July 3, 2023

Re: Venetucci Thompson Thrift  
Traffic Impact Study  
El Paso County, Colorado

Thank you for the Traffic Impact Study email dated June 27, 2023 for the Venetucci Thompson Thrift project. We held a meeting Gilbert LaForce at El Paso County (traffic engineering reviewer), and have made several updates as a result of this meeting and summarized below based on this meeting and your prior comments:

FIGURE 11
 VENETUCCI THOMPSON THRIFT
 EL PASO COUNTY, COLORADO
 ROADWAY OWNERSHIP MAP

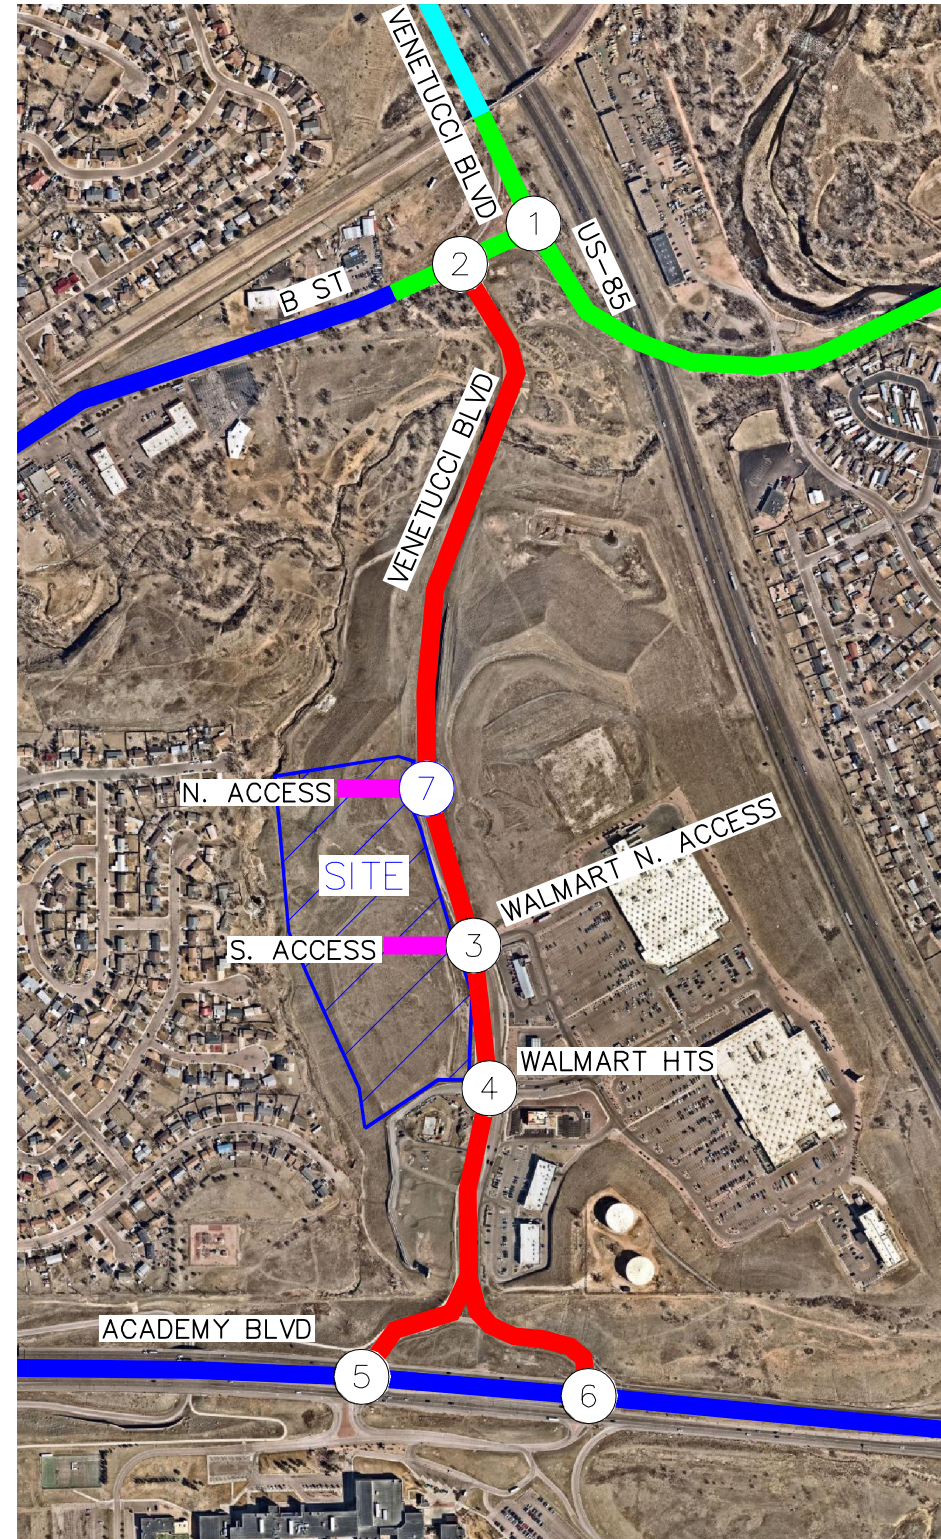
- Based on the request of Gilbert LaForce at El Paso County, we have been in correspondence with CDOT, City of Fountain, City of Colorado Springs, and El Paso County to determine which agency controls each of the roadways in the surrounding area. This is now identified in Figure 11.
